# CITY OF ALBUQUERQUE

June 26, 2006

**Re: Longfellow Elementary, 400 Edith Blvd NE**  
**Grading and Drainage Plan**  
**Engineer's Stamp dated 6-23-06 (K14-D10)**

GRADING & DRAINAGE DETAILS

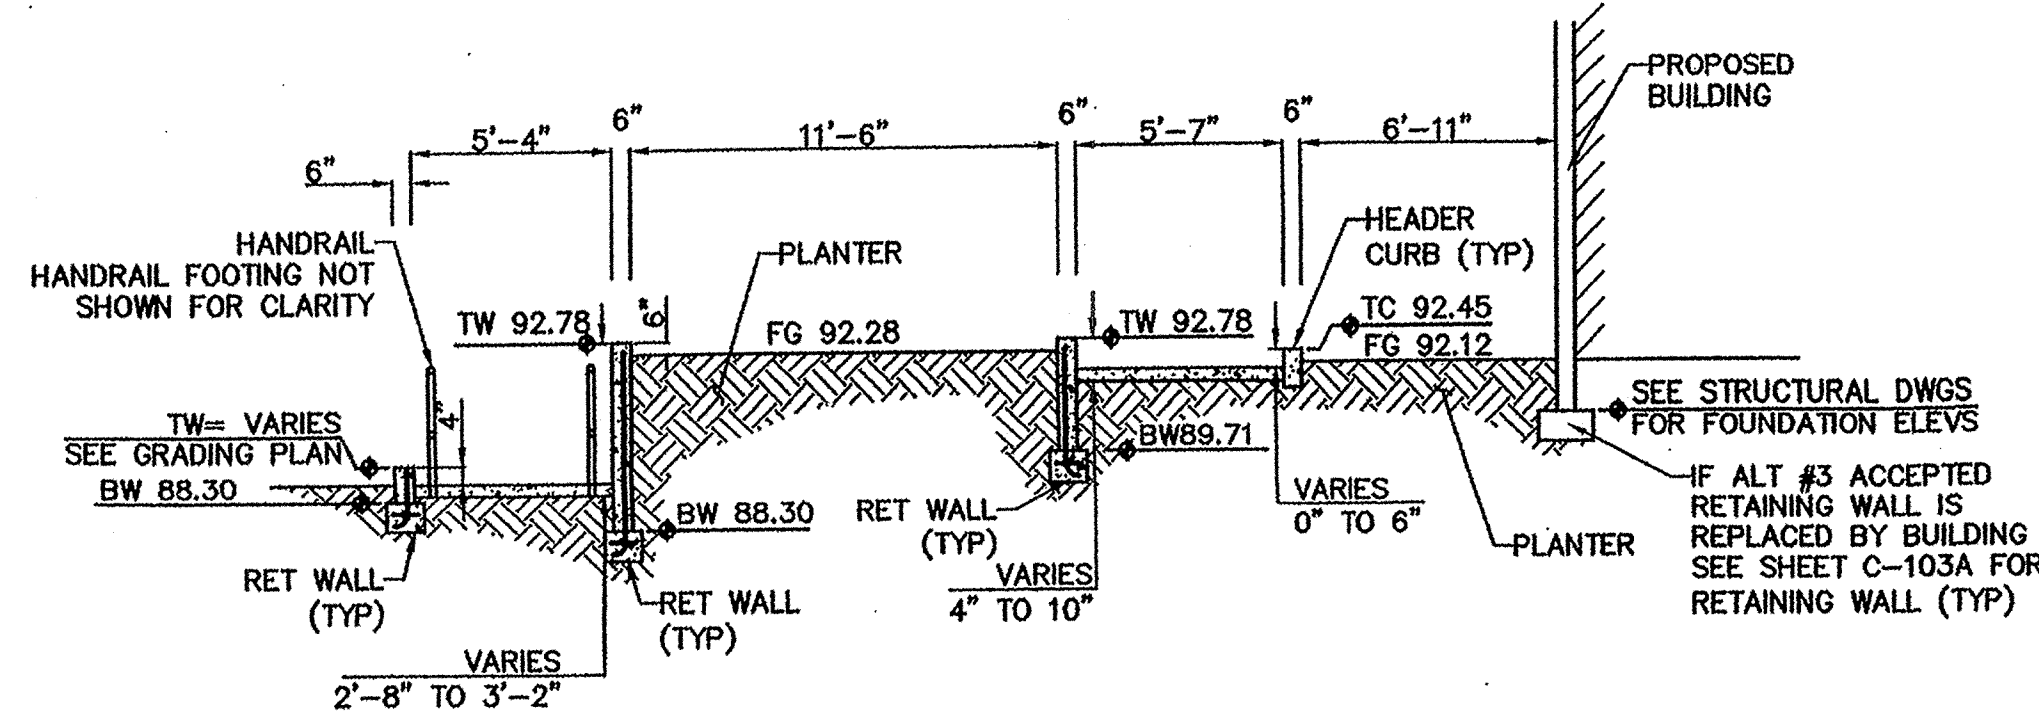
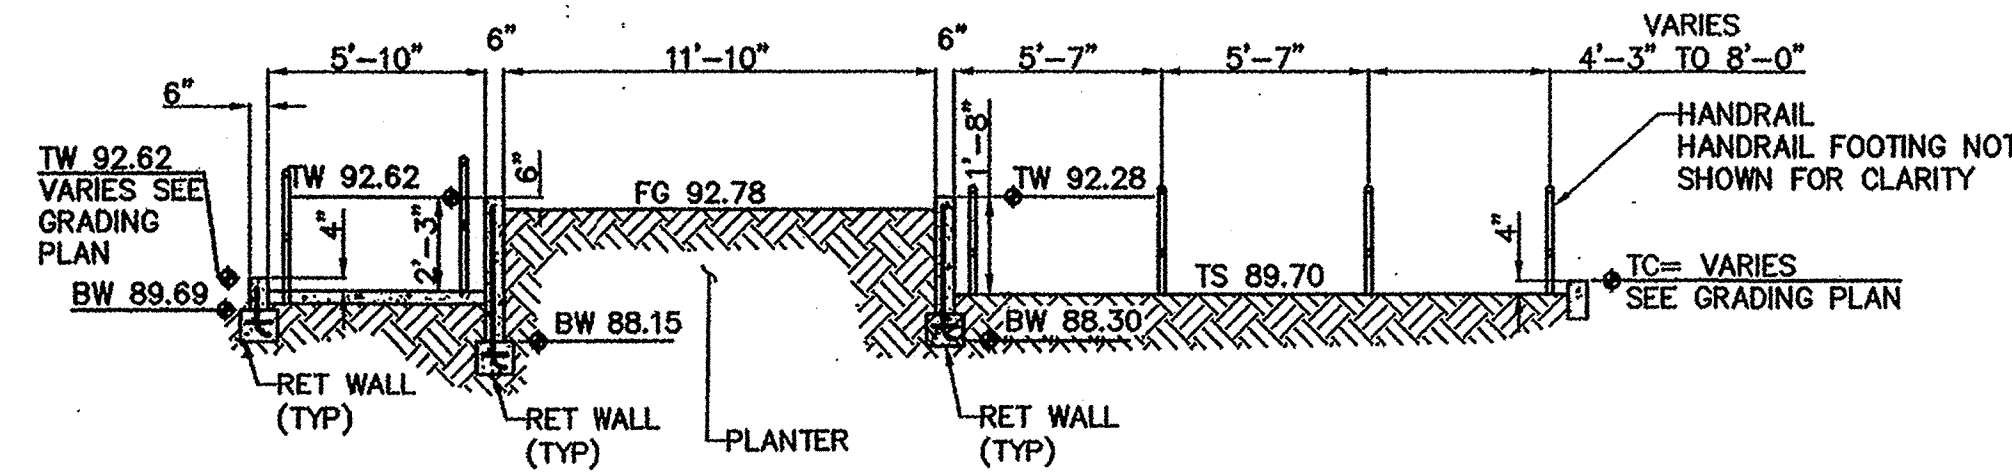
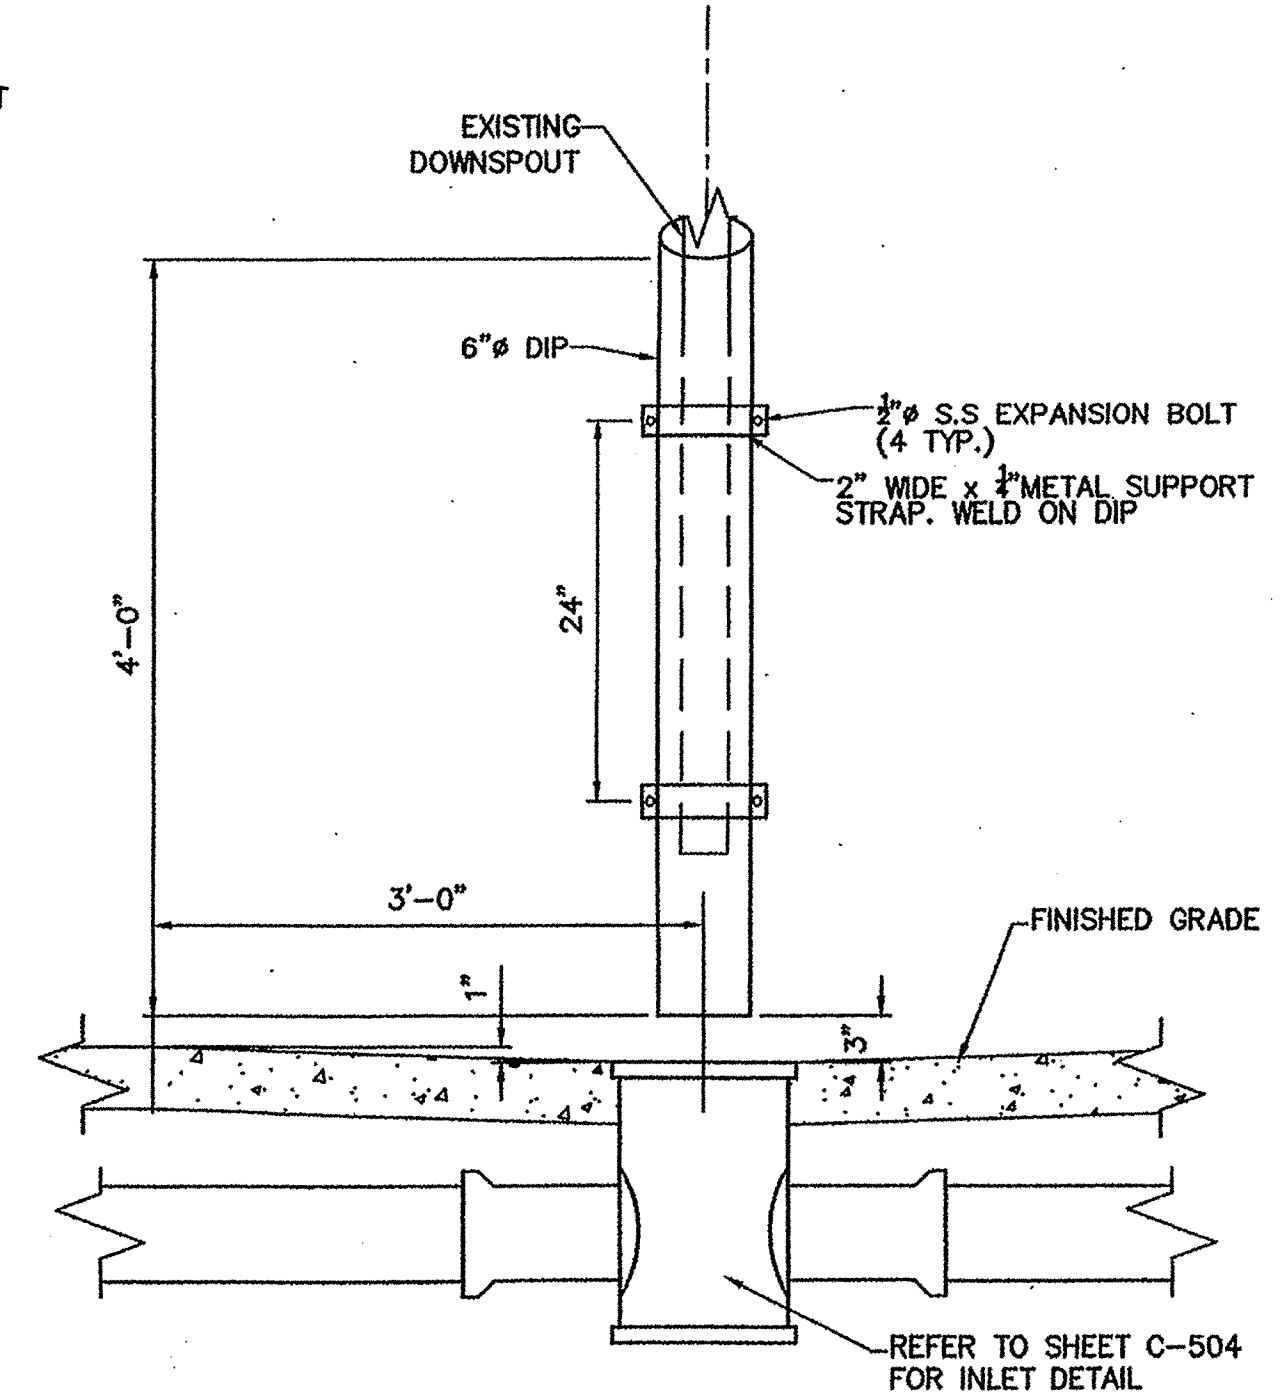
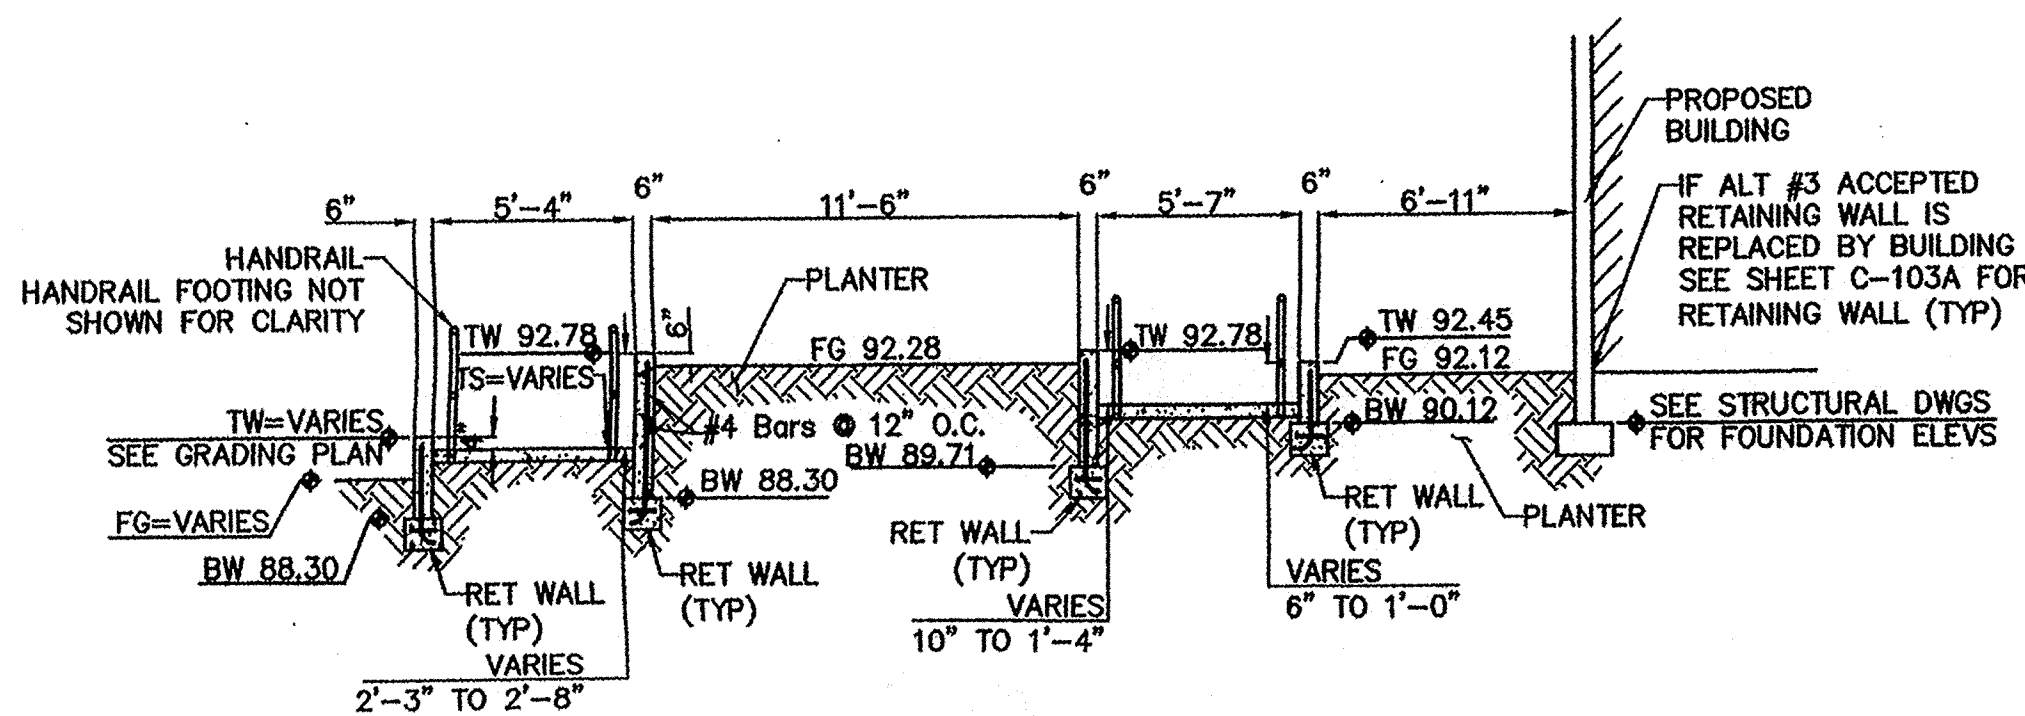
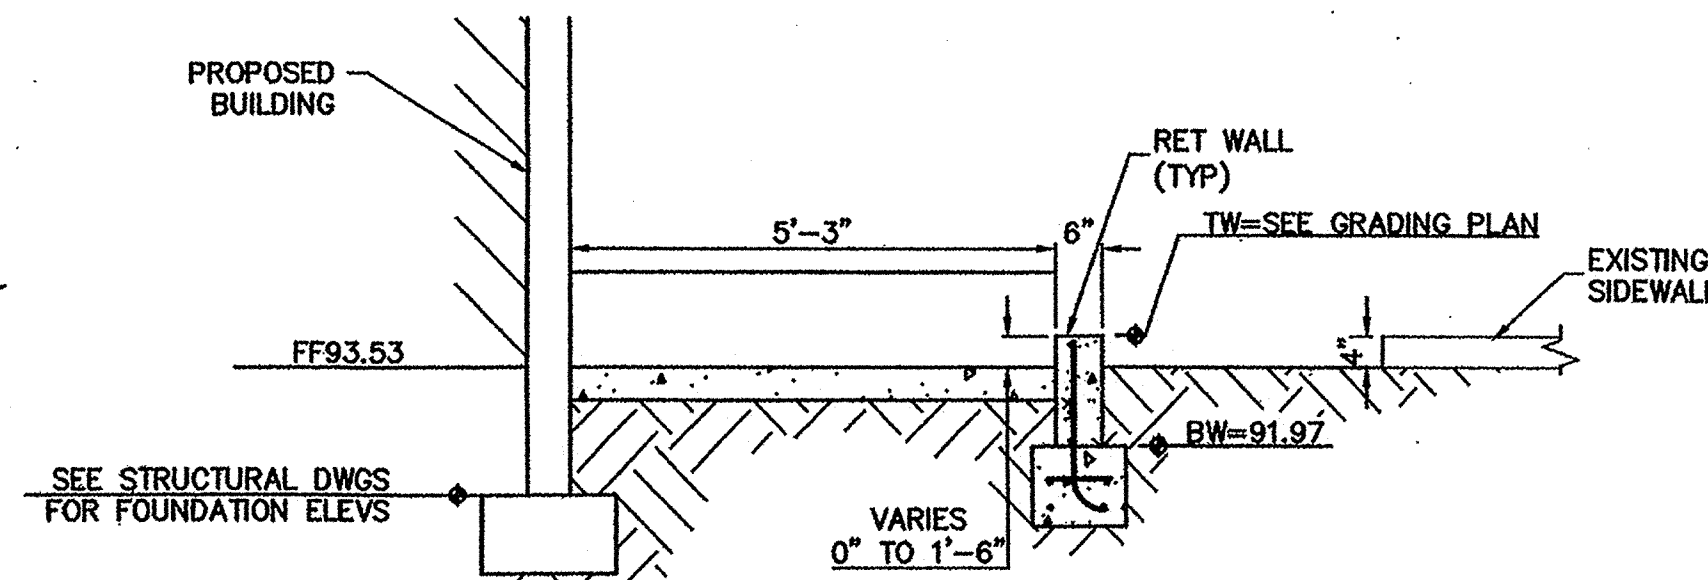
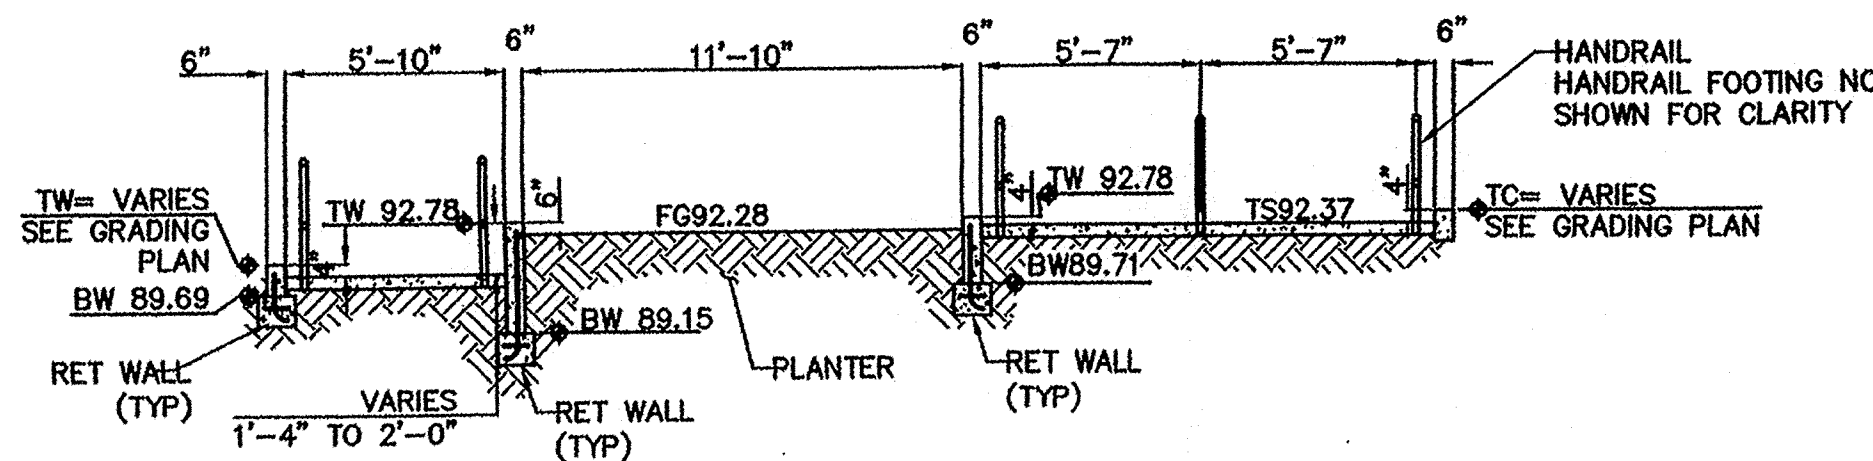
1. Please add pipe sizes and inverts at all appropriate locations for the intended infrastructure.
2. Please add dimensions for the drop inlets or reference COA Standards.
3. Add all build notes for infiltration gallery and outlets.
4. Are weep holes at grade? Why are you installing weep holes?

This plan needs to be constructible. If I have these types of questions so will the contractor. It is not prudent to make the contractor guess or figure out in the field what would be appropriate. If you have any questions, you can contact me at 924-3986.
